CITY OF ALBUQUERQUE

June 21, 2017

**RE: Glendesto Subdivision
Grading Plan and Drainage Report
Engineers Stamp Date: 6/15/17
Hydrology File: B18D020**

Based on the information provided in your submittal received on 6/16/17, the Grading Plan and Drainage Report are not approved for Grading Permit or Preliminary Plat. The following comments must be addressed prior to approval:

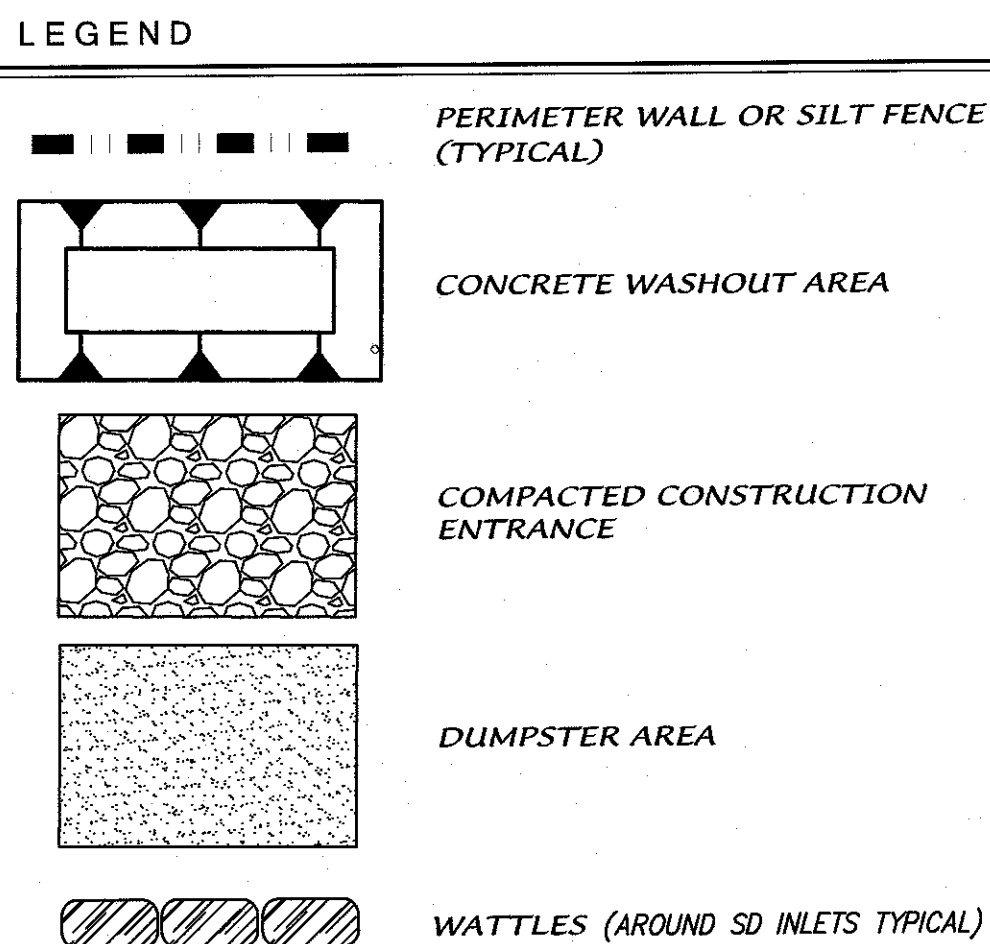
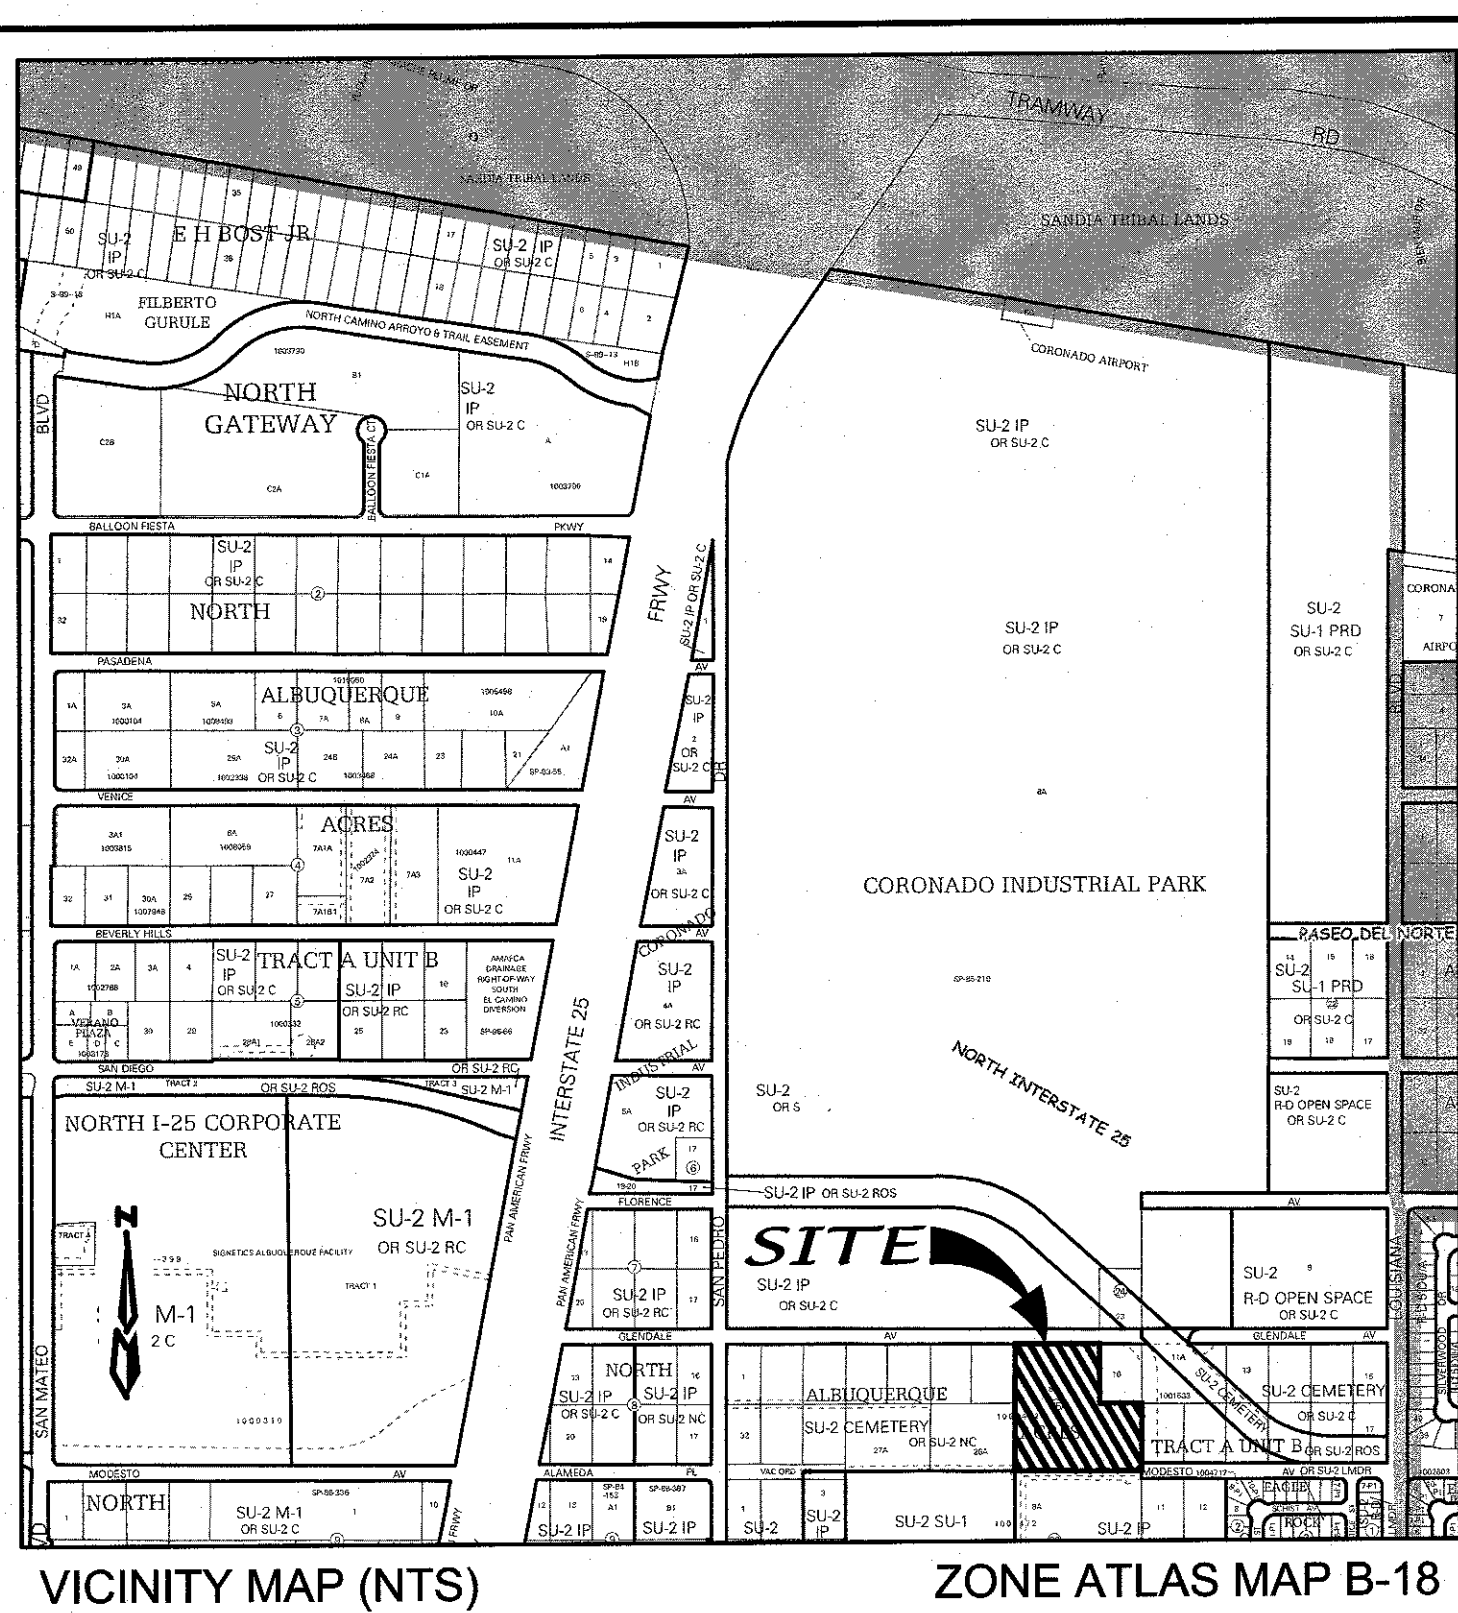
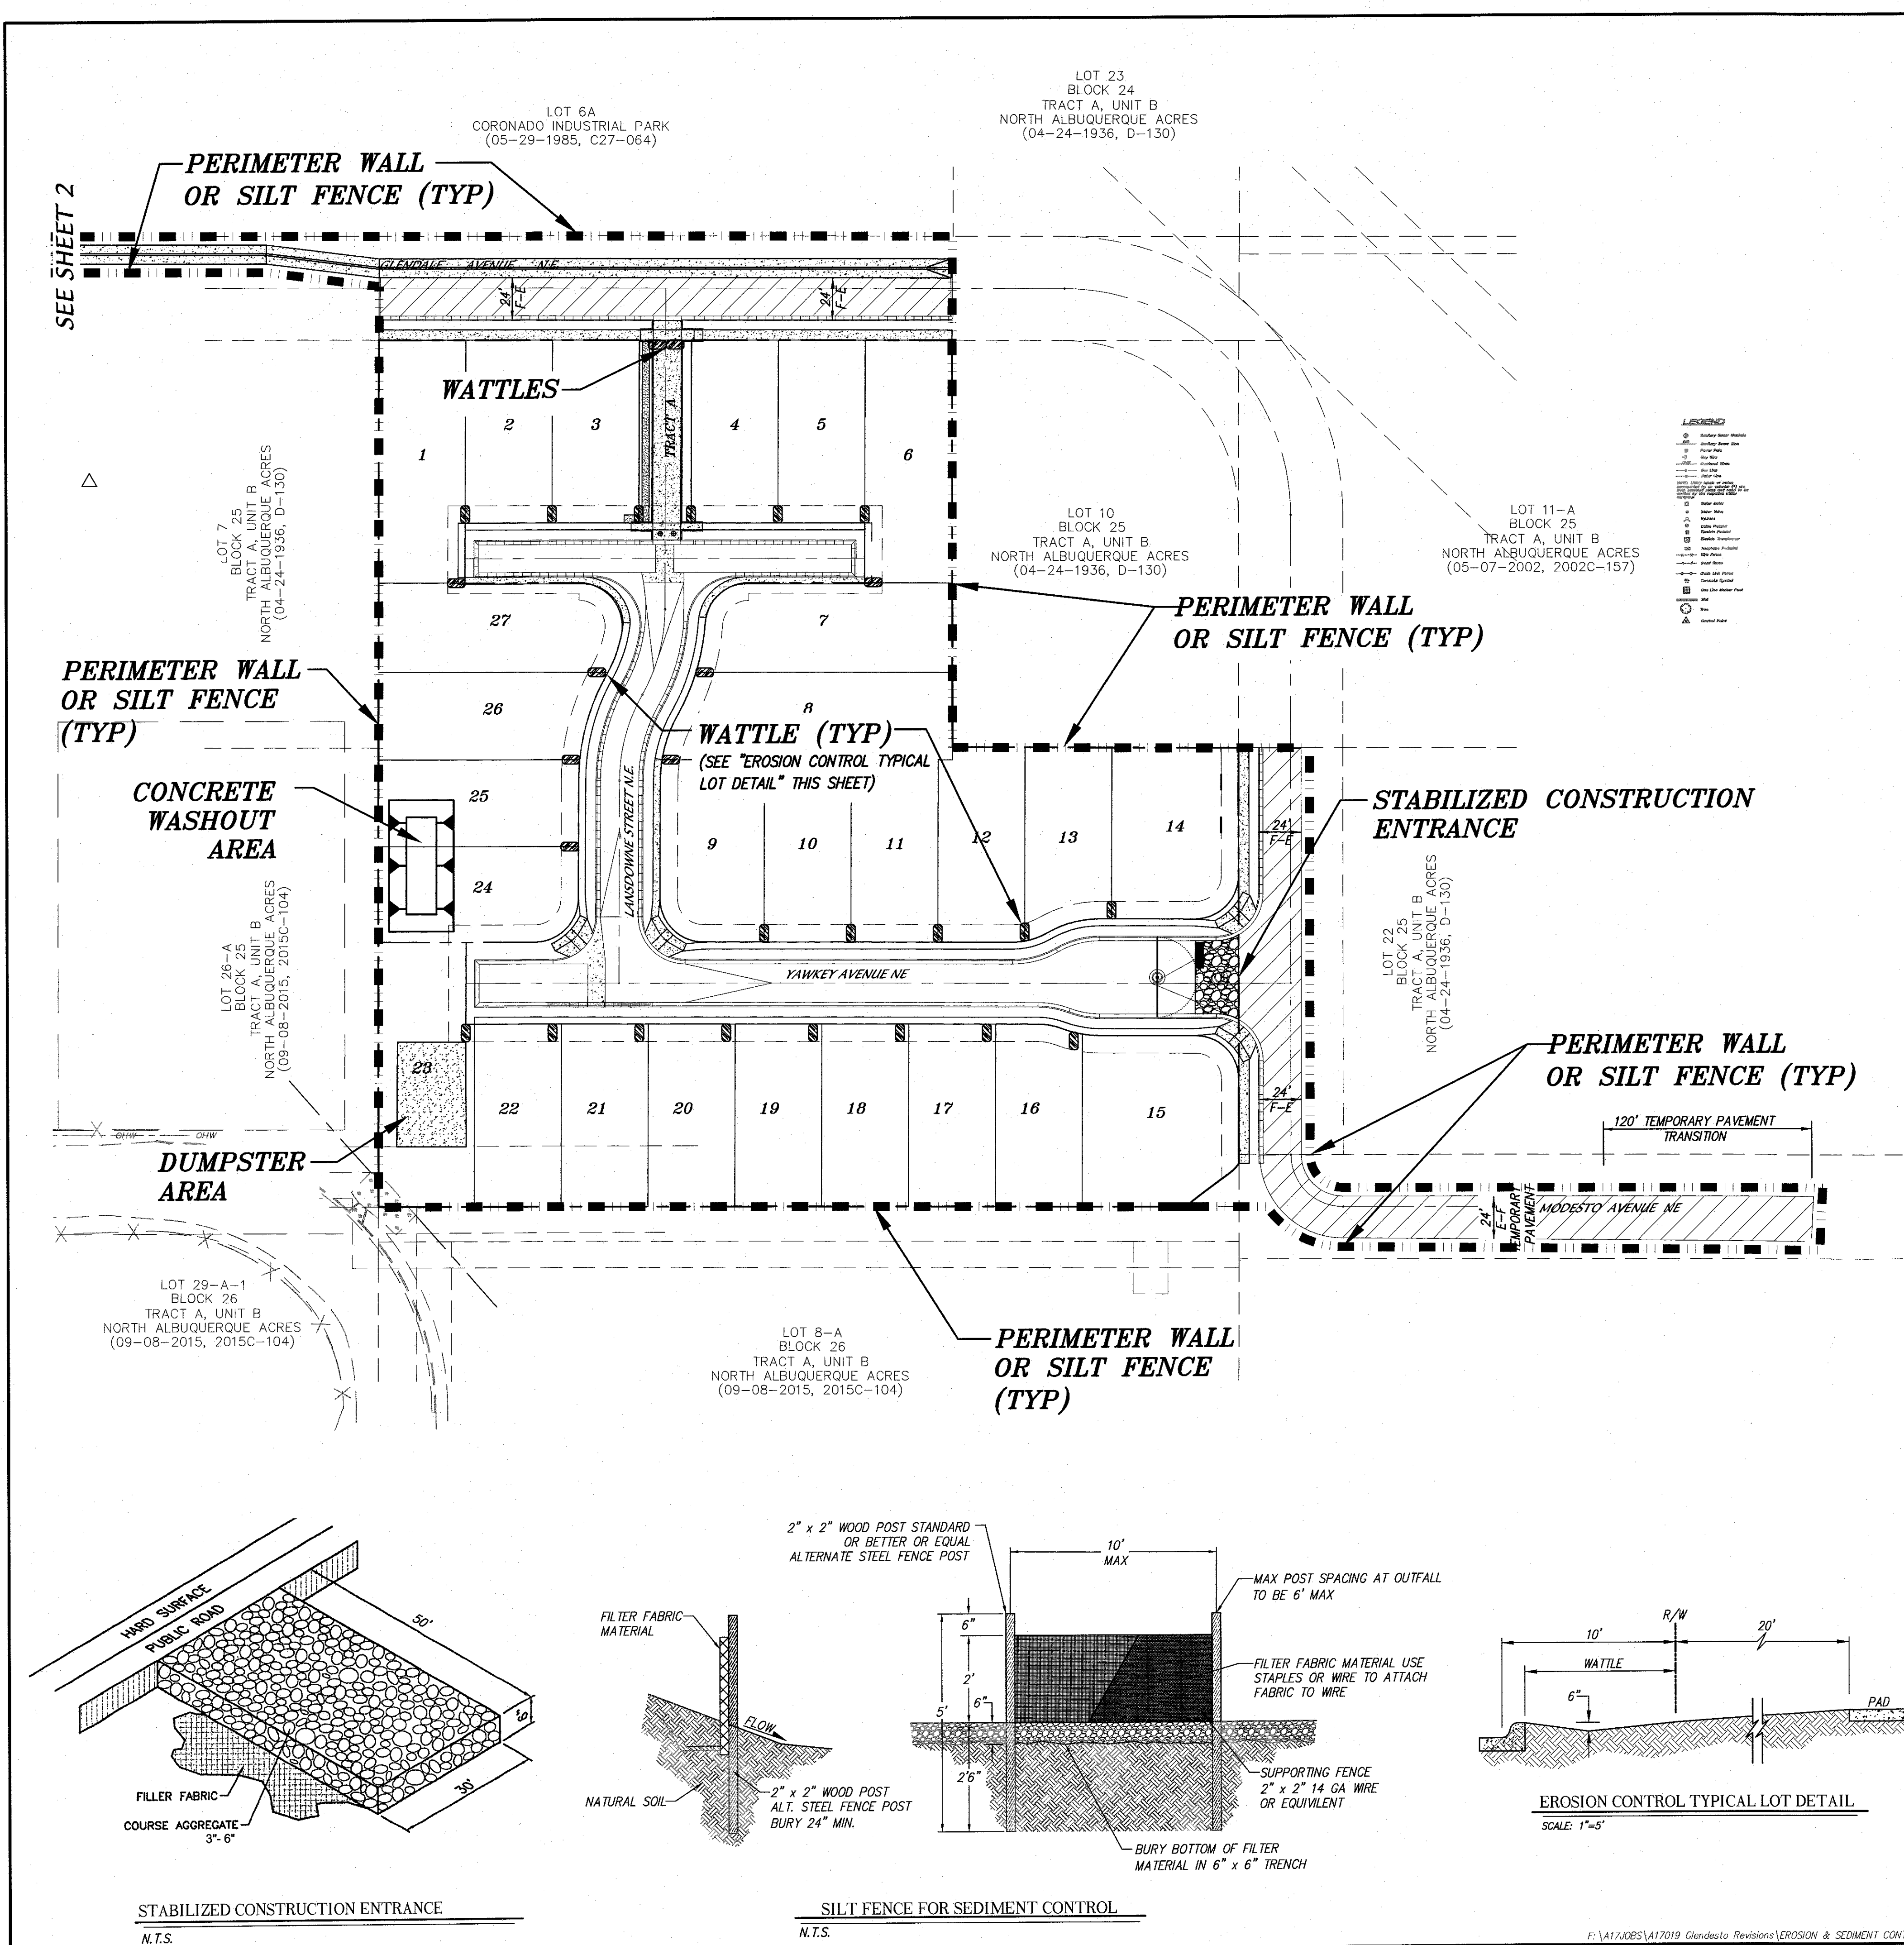
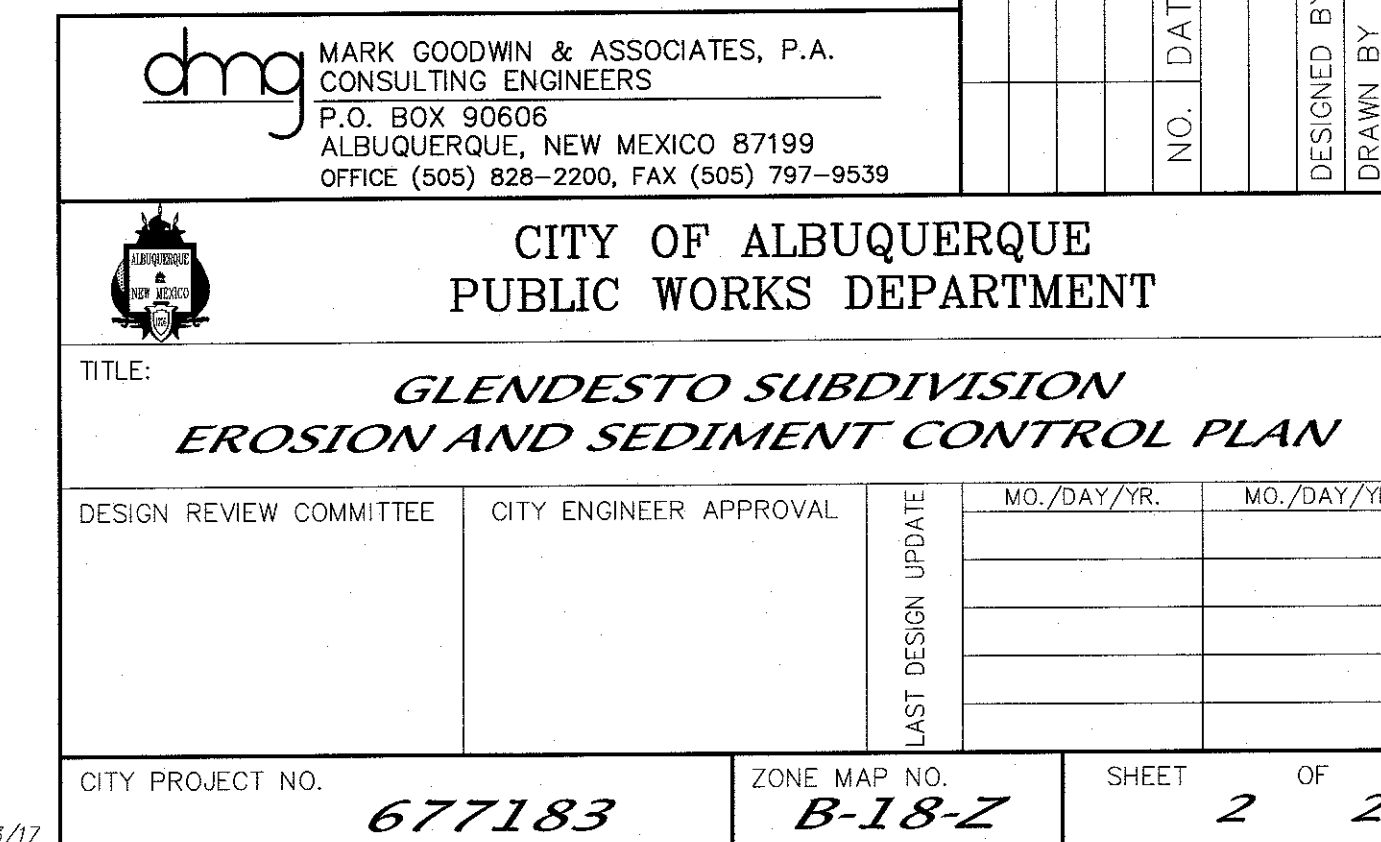
5. Recheck the pad elevations. Many pads have enough elevation difference to require retaining walls in between lots such as: lot 21, and lot 24/25.
6. A revised ESC plan is required prior to Grading Permit approval.
